National Infrastructure Planning  
Temple Quay House  
2 The Square  
Bristol, BS1 6PN

Our Ref: EN010127

### **Application by Mallard Pass Solar Farm Limited for an Order Granting Development Consent for the Mallard Pass Solar Project**

#### **Advice following issue of decision to accept the application for examination**

C:\USERS\GFLETCHER\PTV\PT - CAD\LDA_4990\2002_MALLARD PASS SOLAR FARM\CAD11.0.CURRENT\11.0.1.SHEETS\PROWS\4990-2001-T-079-089-P1 - TRAFFIC REGULATION MEASURES PLANS - TEMPORARY MEASURES.DWG

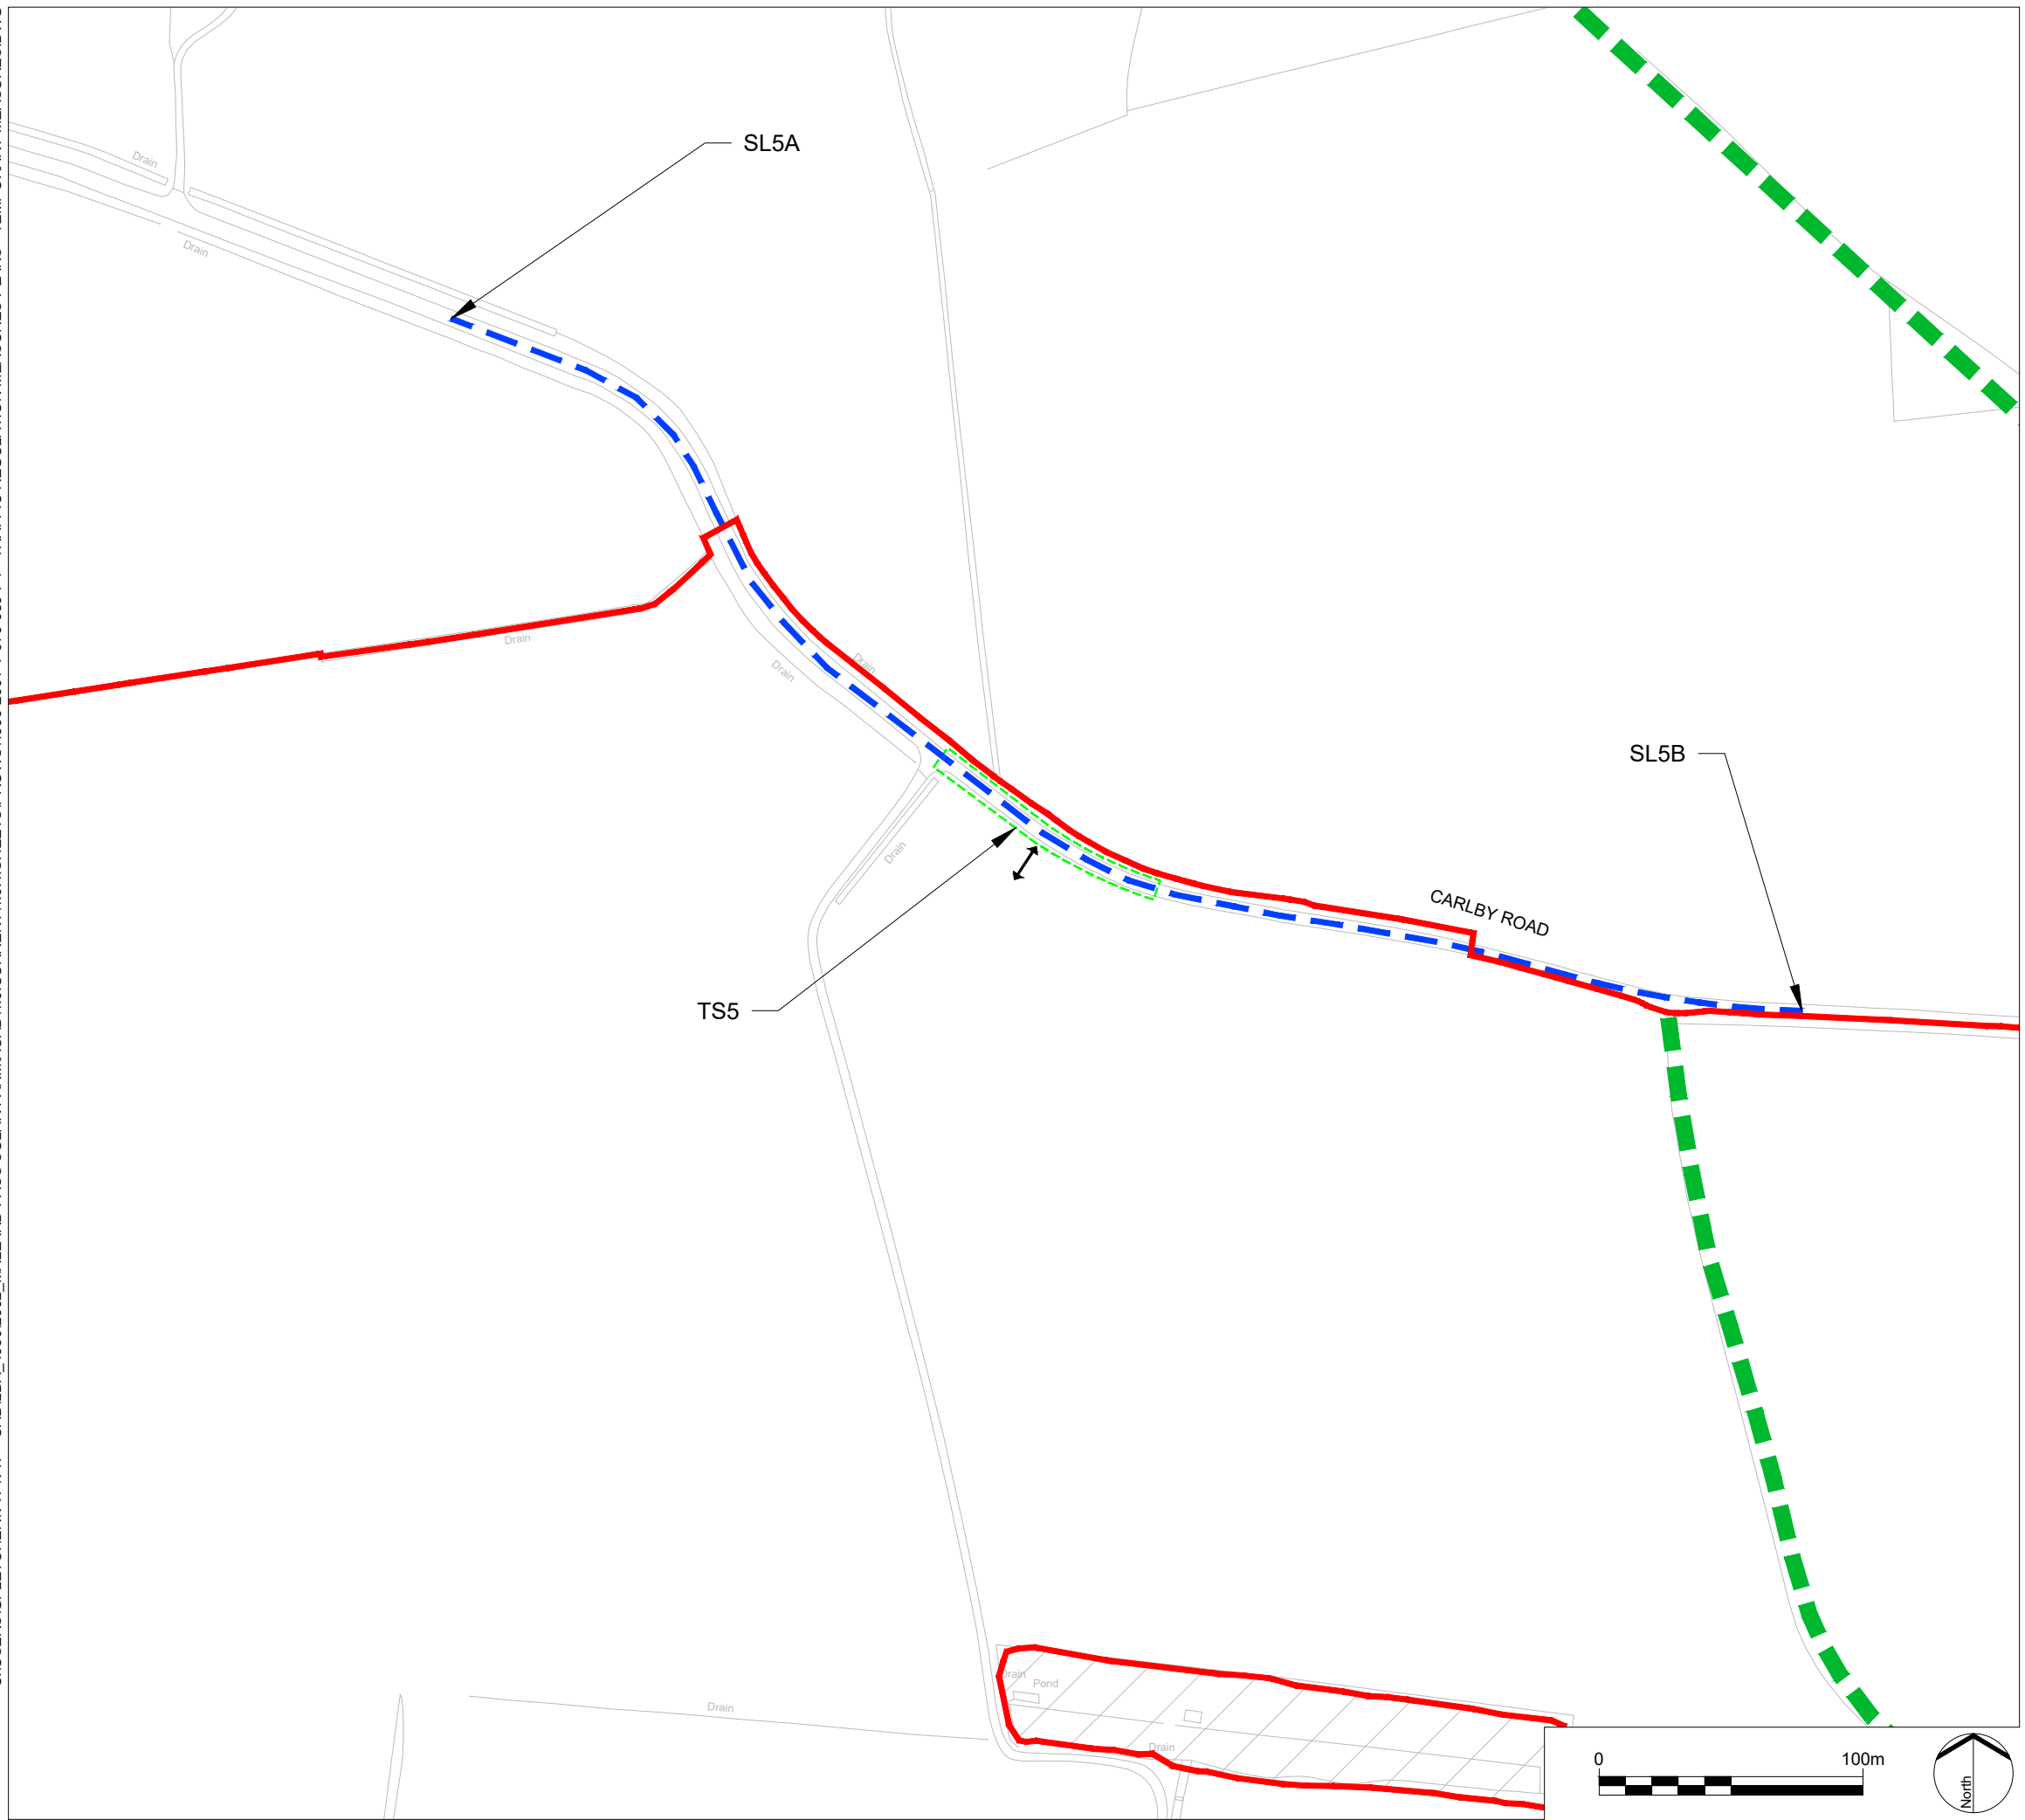
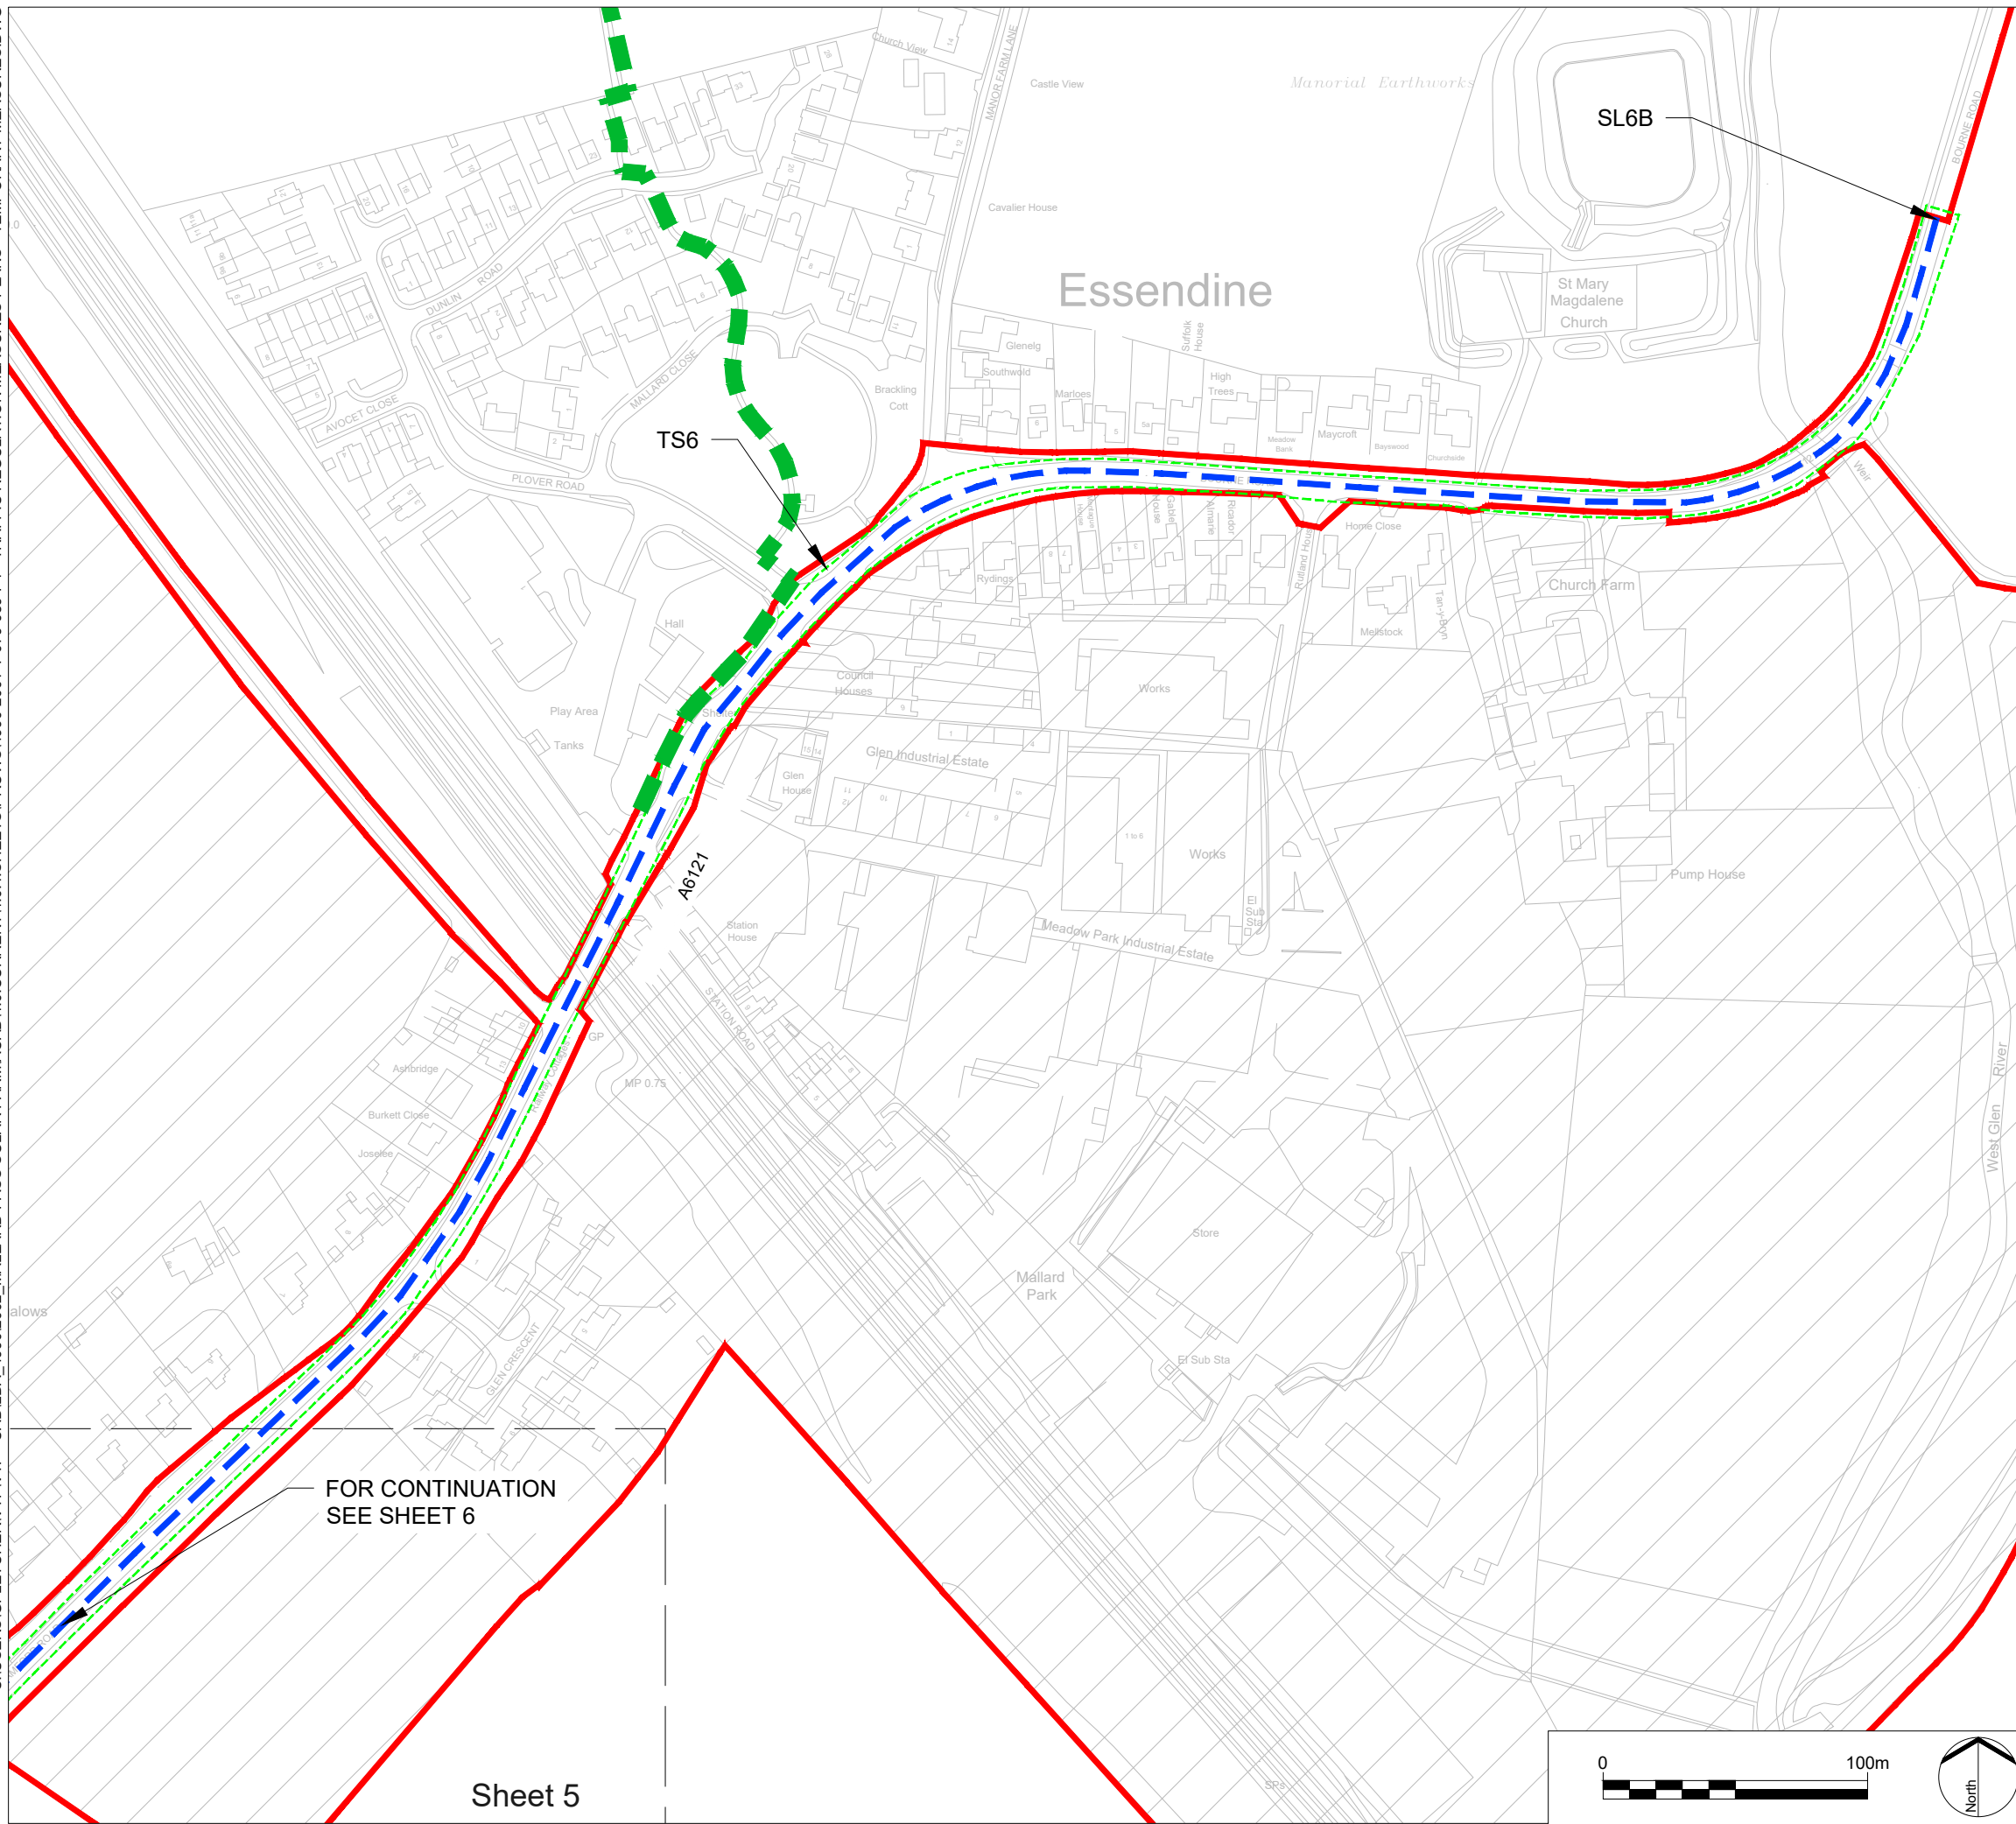
For clarity and to help understanding, existing public footpaths (public rights of way) should be marked and the plans more clearly notated to reflect the proposals, including differentiating works to footpaths and roads.
